2200 Sunport Blvd. SE

Administrative Amendment Request

Project #PR- 2018-001575

Transportation Development Comments:

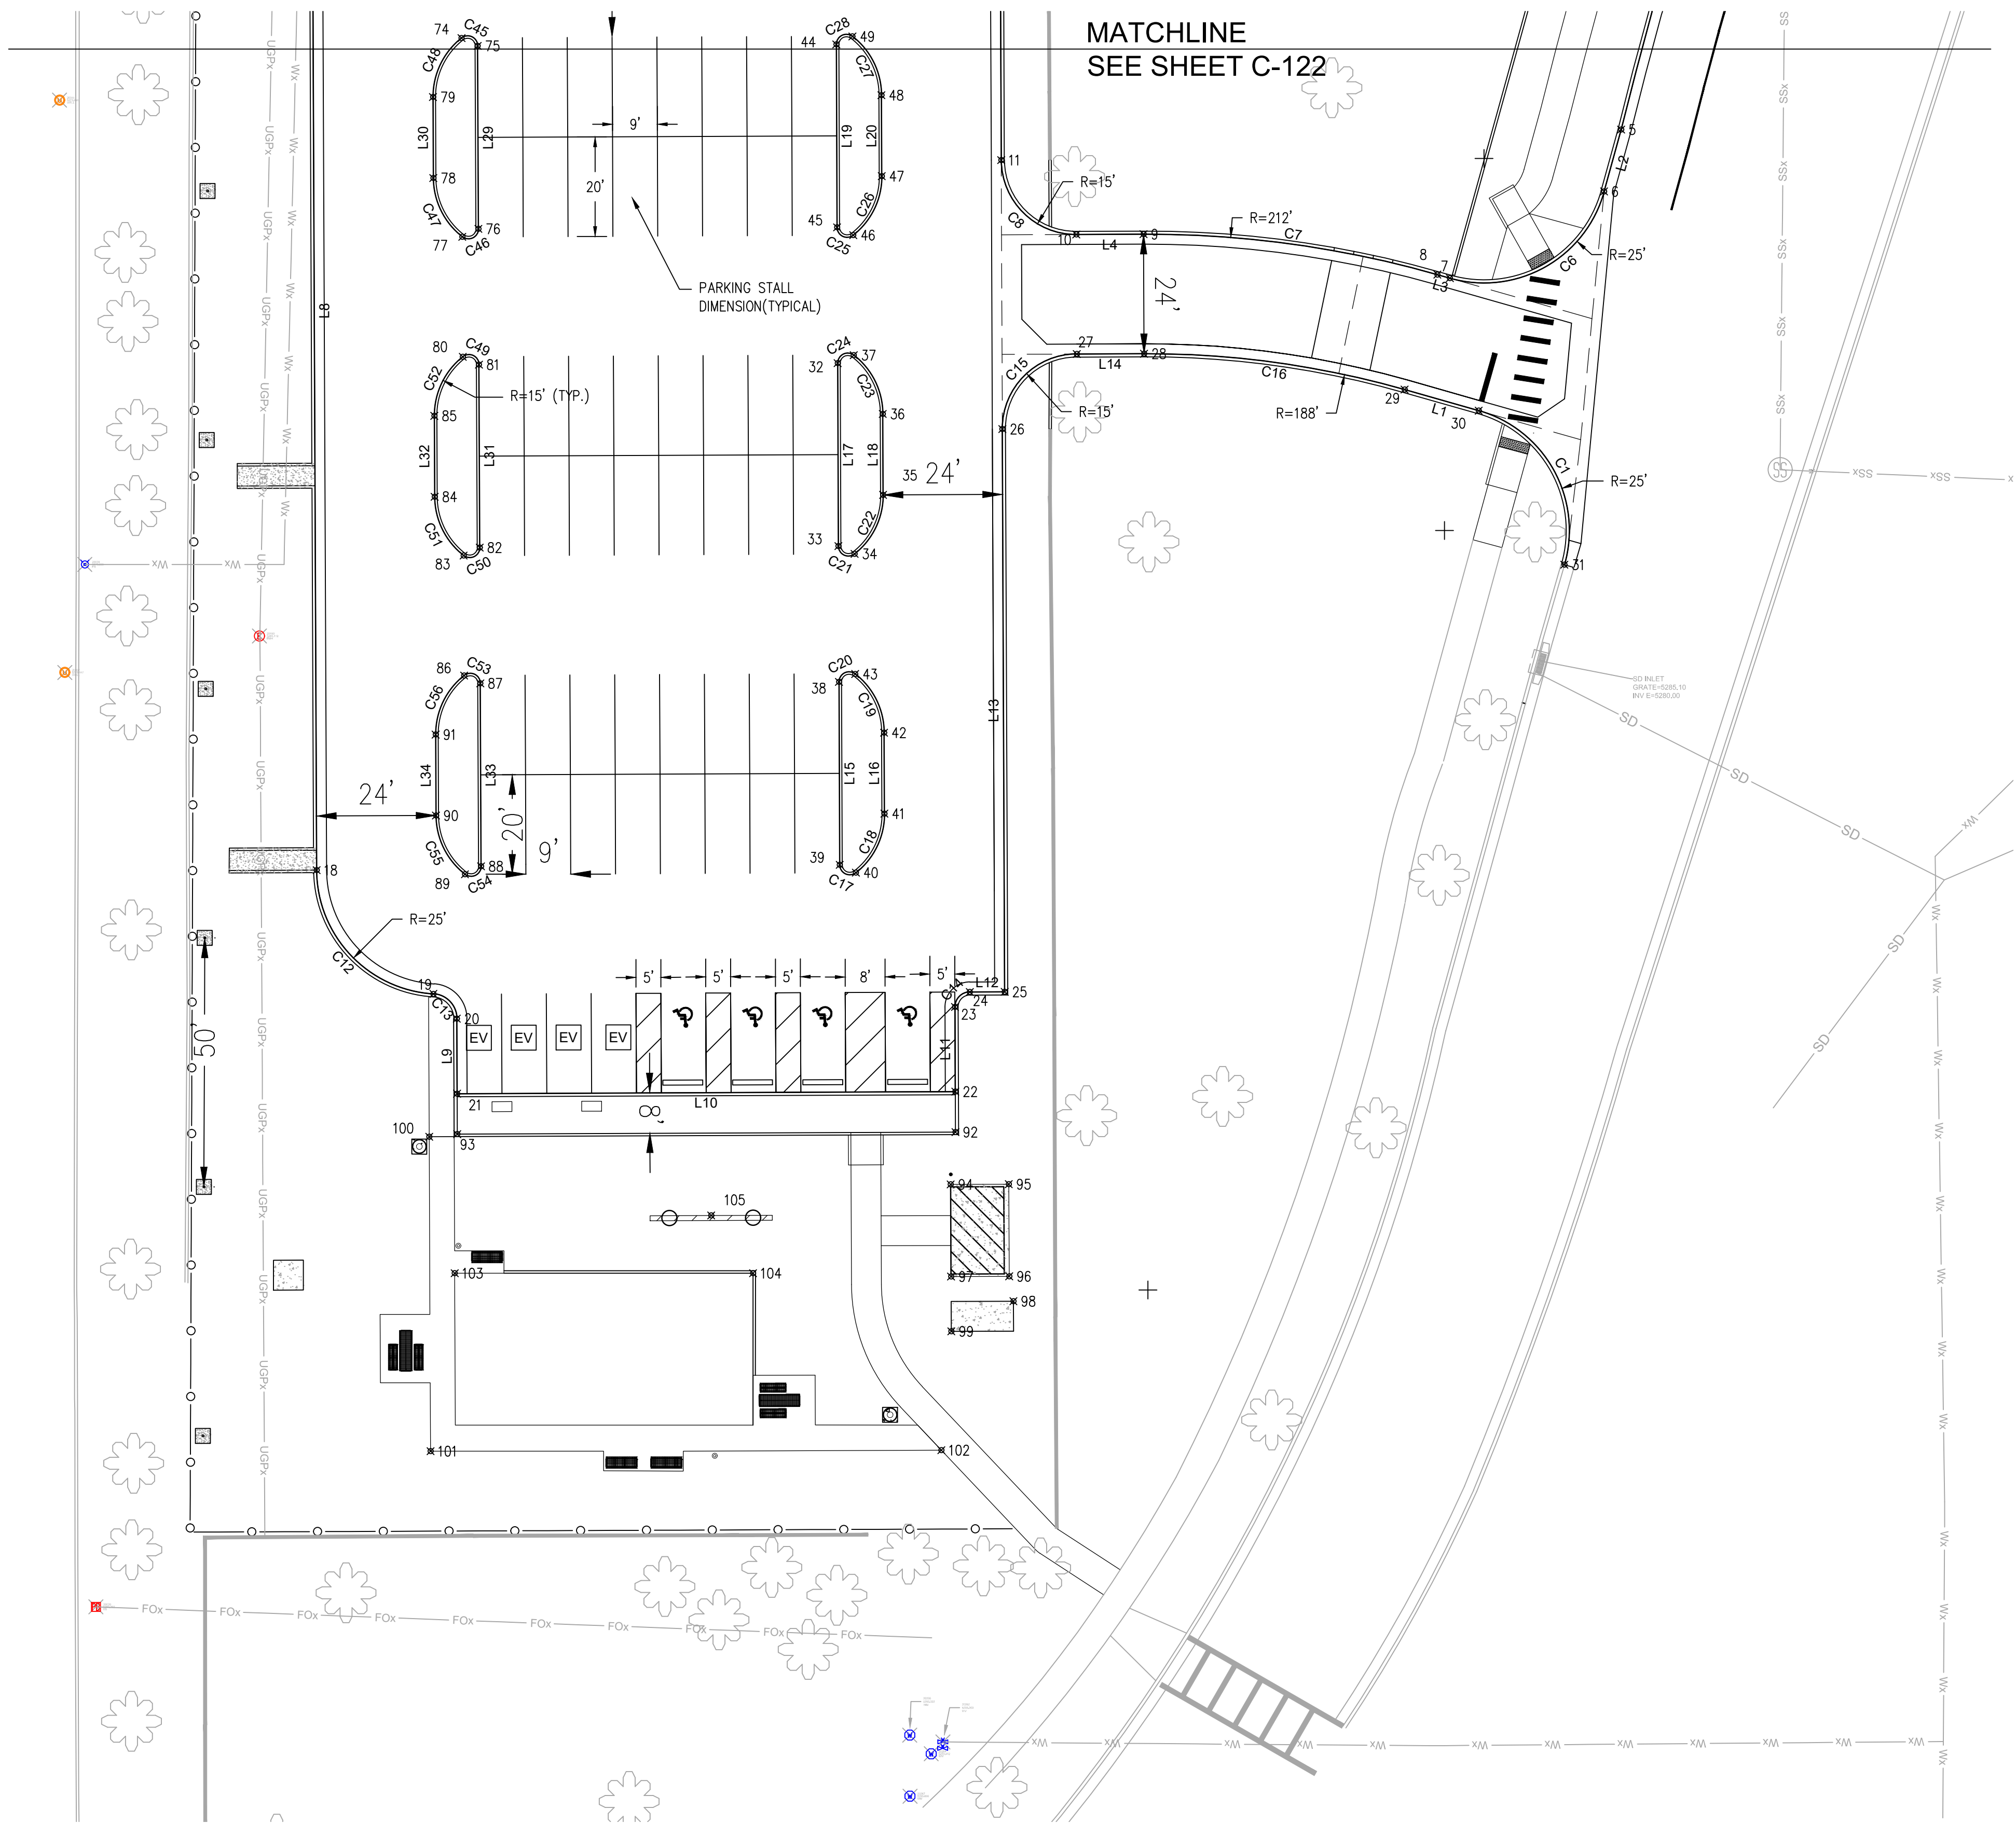
7. List radii for all curves shown; for passenger vehicles. Radius for delivery trucks, fire trucks, etc. is 25 ft. or larger. (Radius provided on sheet C-121 & C-122 where fire trucks access in and out of the project site)
8. Provide pedestrian ramp details with truncated domes. (City of Albuquerque standard curb ramp with truncated domes, see Detail 1, sheet C-503.)
9. Will the highlighted area on the west end of the property (red) be a park? Please provide clarification. See image below.(Area for rest or dog relieve

4
C-501

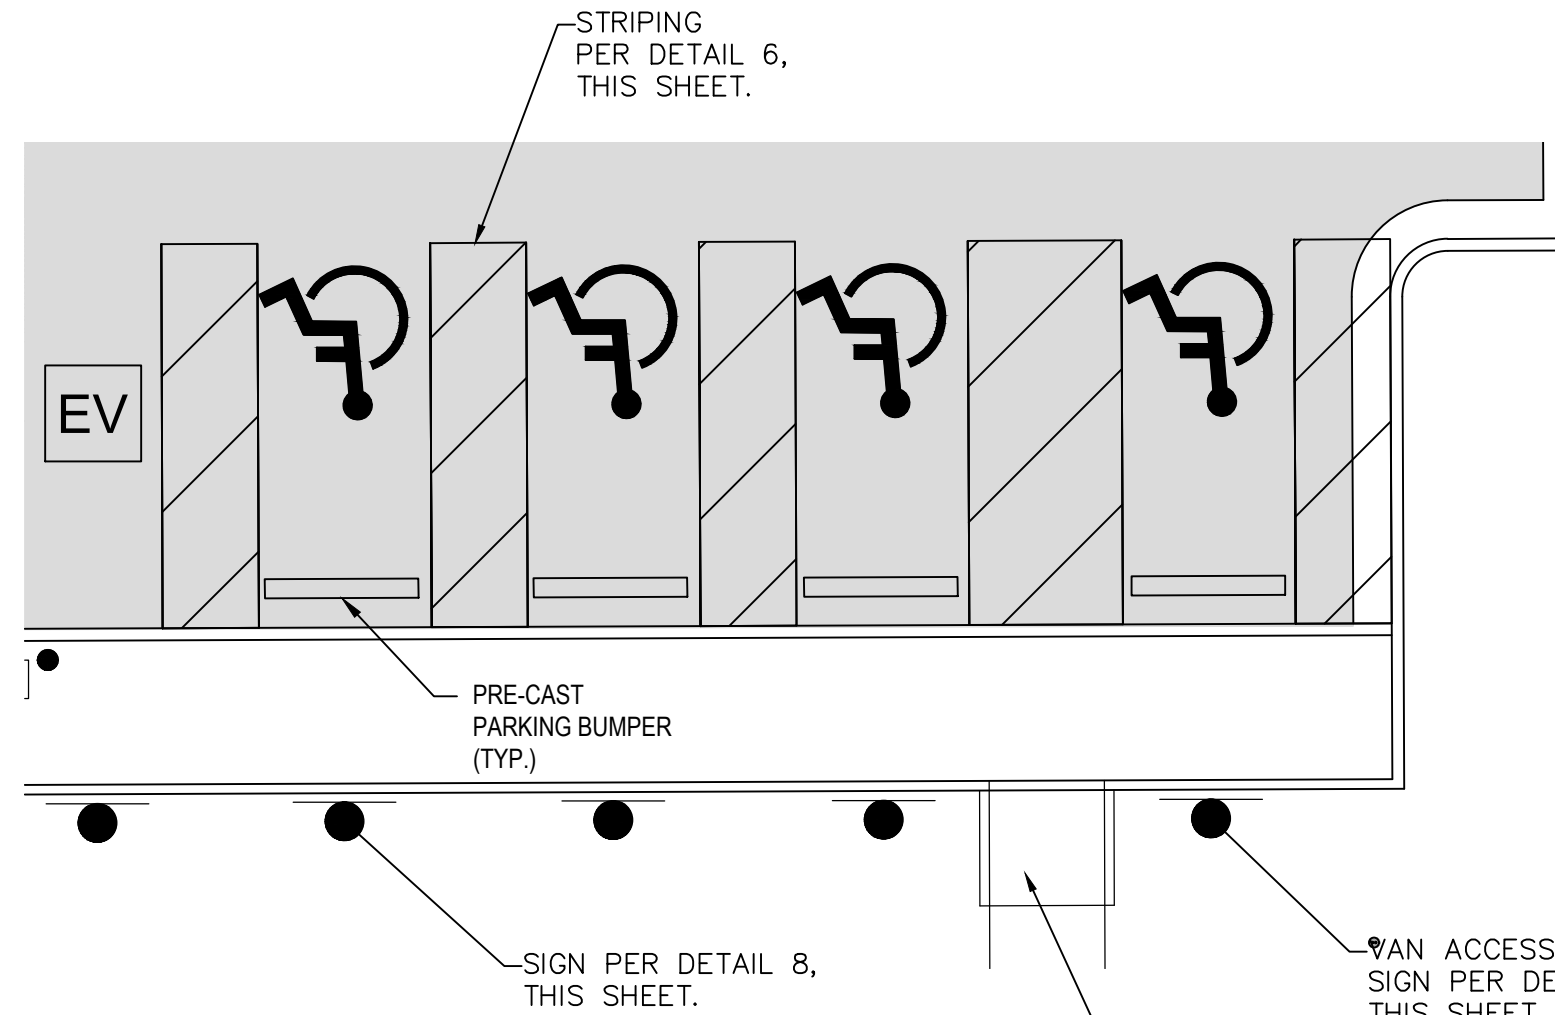
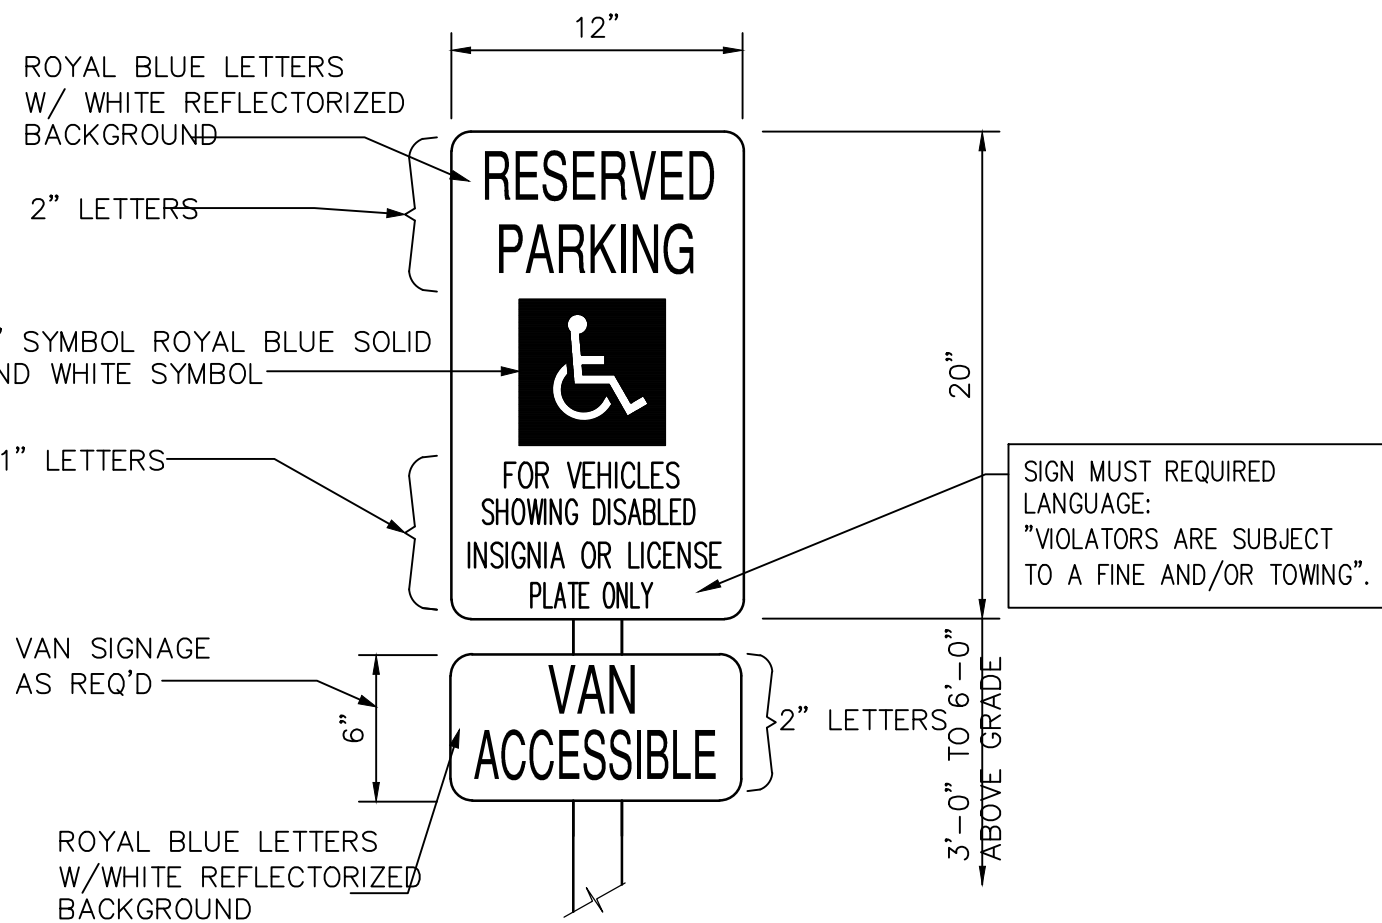
2. The ADA accessible parking sign must have the required language per 66-7-352.4C NMSA 1978 **"Violators Are Subject to a Fine and/or Towing."** Please show sign face details.(Concur, see detail 8, sheet C-501)

3. The ADA access aisles shall have the words **"NO PARKING"** in capital letters, each of which shall be at least one foot high and at least two inches wide, placed at the rear of the parking space so as to be close to where an adjacent vehicle's rear tire would be placed. (66-1-4.1.B NMSA 1978) (Concur, notes provided to detail 6, sheet C-501.)
